CITY OF ALBUQUERQUE

August 28, 2025

**RE: Montgomery Crossing
8810 Montgomery Blvd NE
Grading and Drainage Plan
Engineer's Stamp Date: 08/22/2025
Hydrology File: G20D054
Case # HYDR-2025-00309**

GRADING PLAN
 MONTGOMERY CROSSING

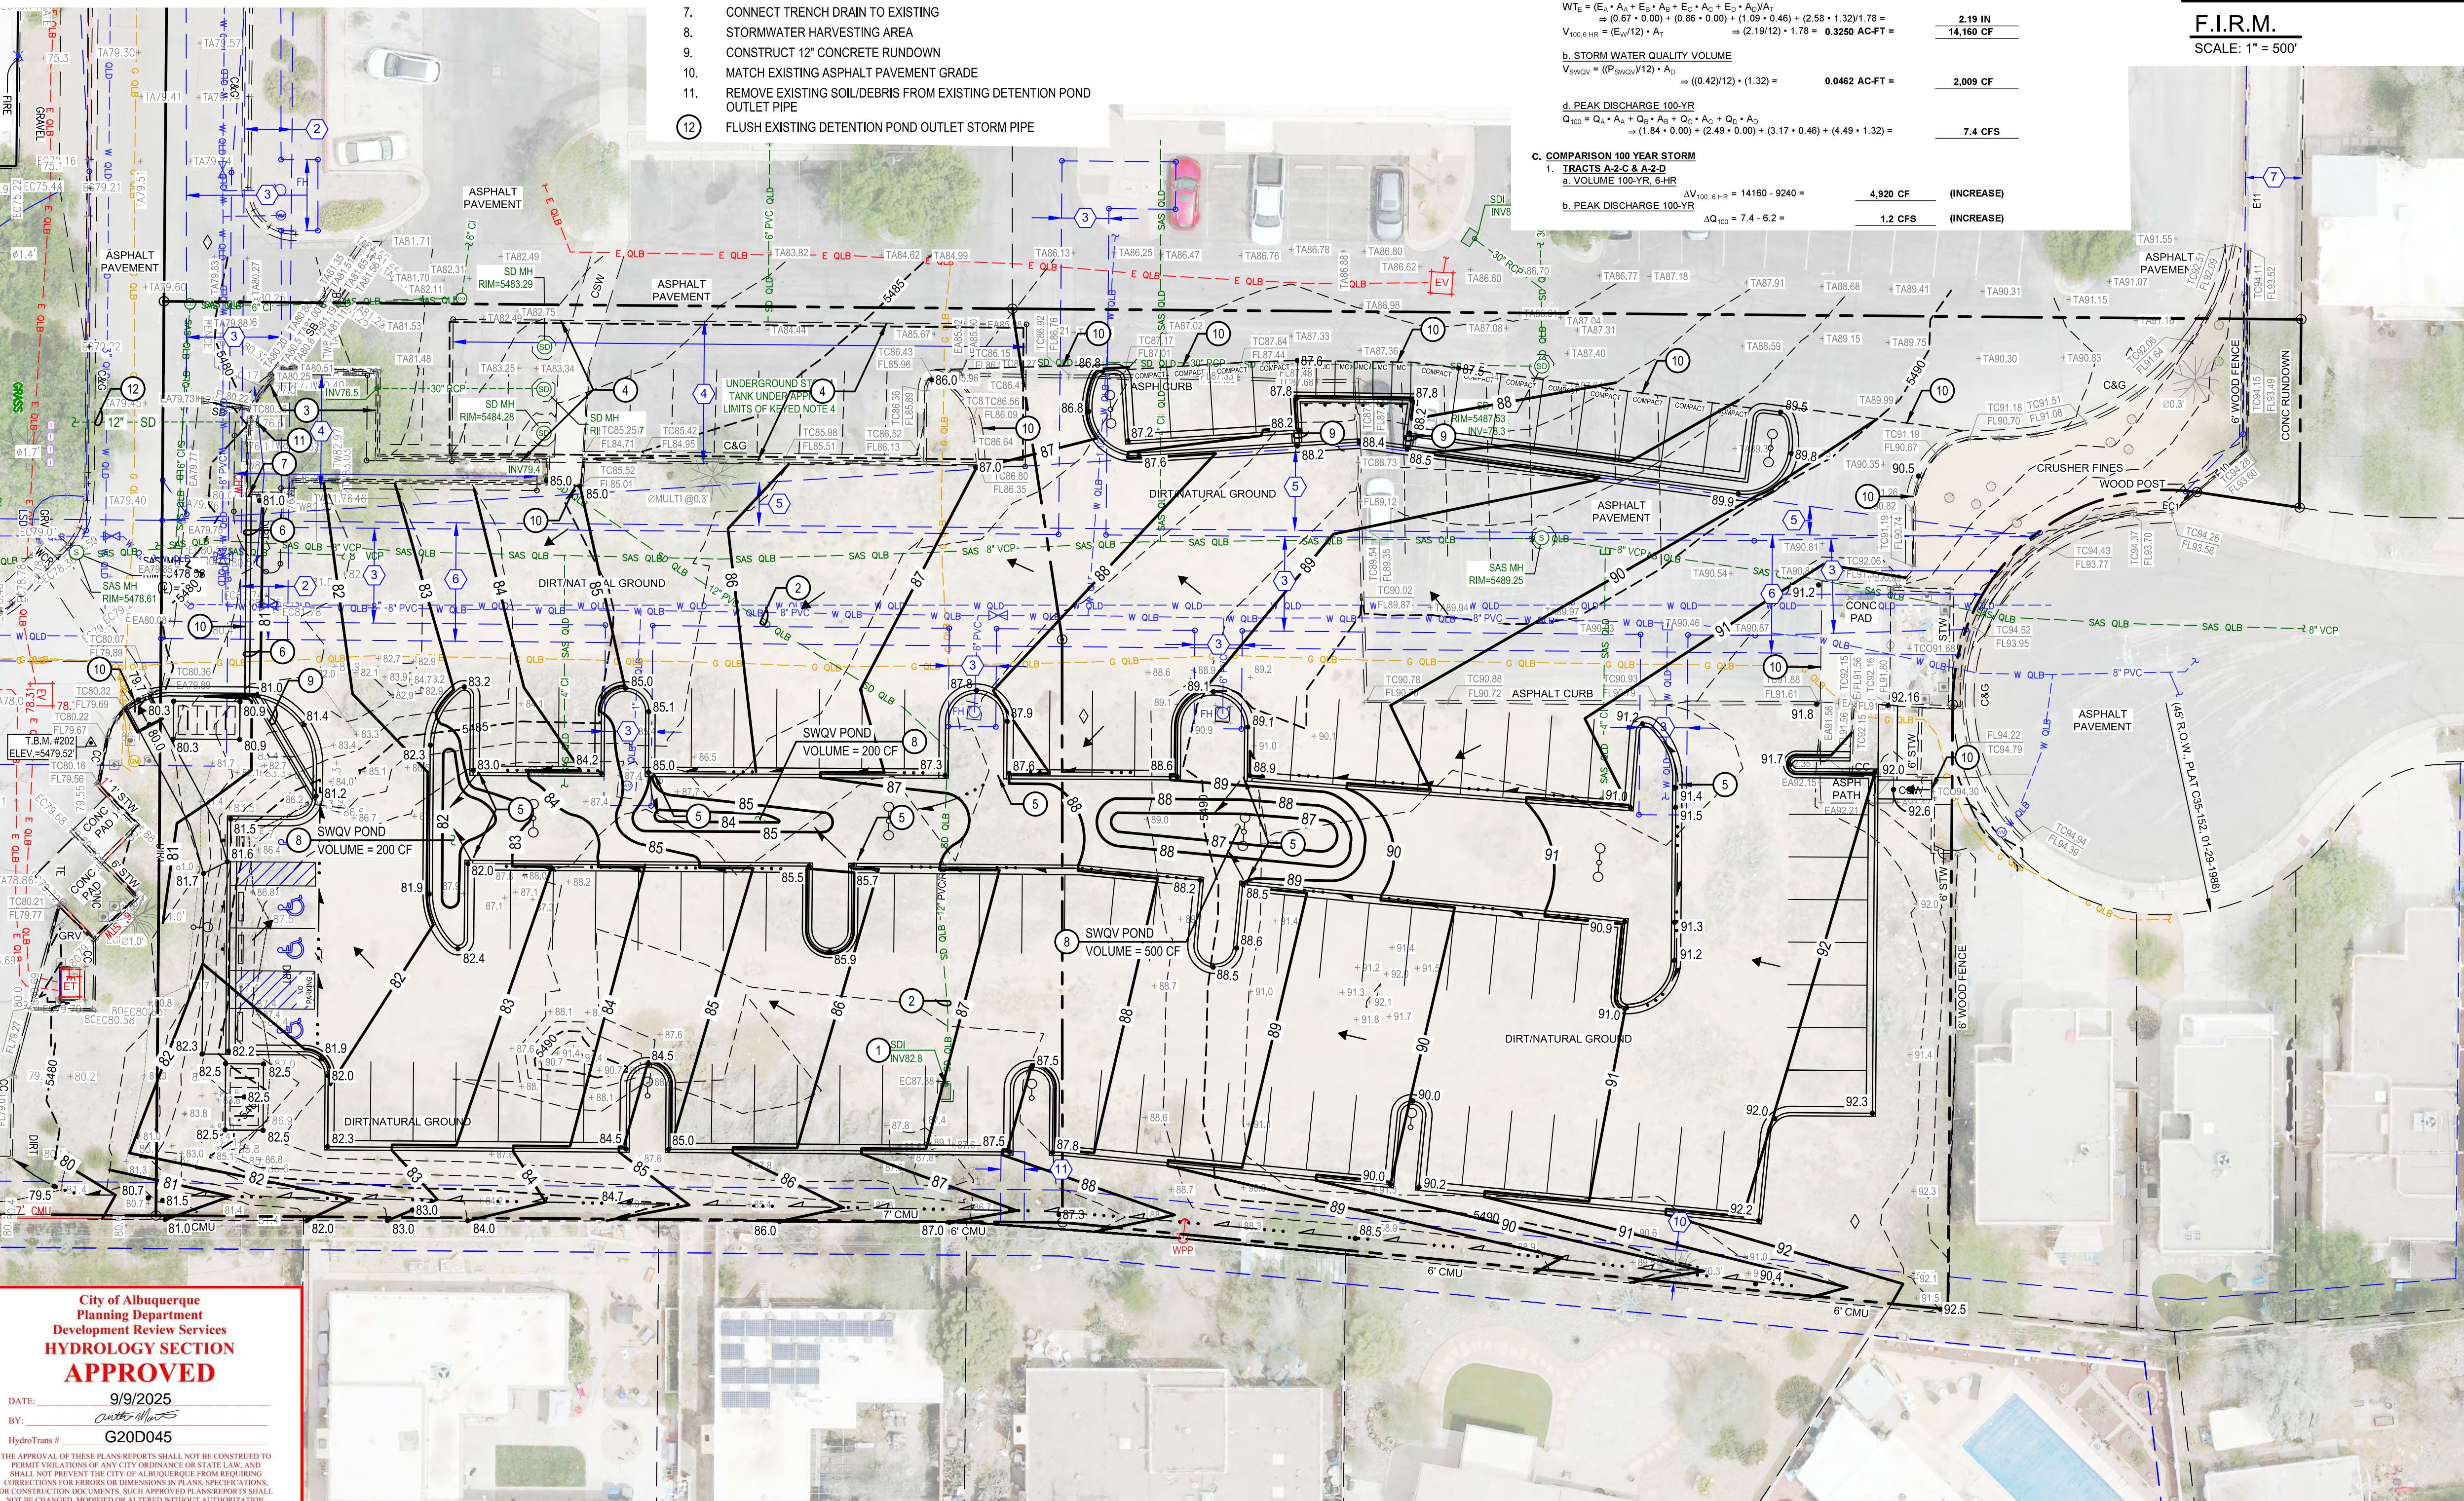
1. Update the Calculations Section for Zone 3.

2. SWQV calculation: Re-check calculation to show 2009 cf required. The area for treatment D is 1.32 acres. $(1.78 \times .74) =$

3. Update VIII. Conclusions #5 with new values per comment #2.
4. Fill out the Waiver Application and email to amontoya@cabq.gov for review and approval. As a reminder, the Payment-In-Liew will need to be paid prior to release of permits.
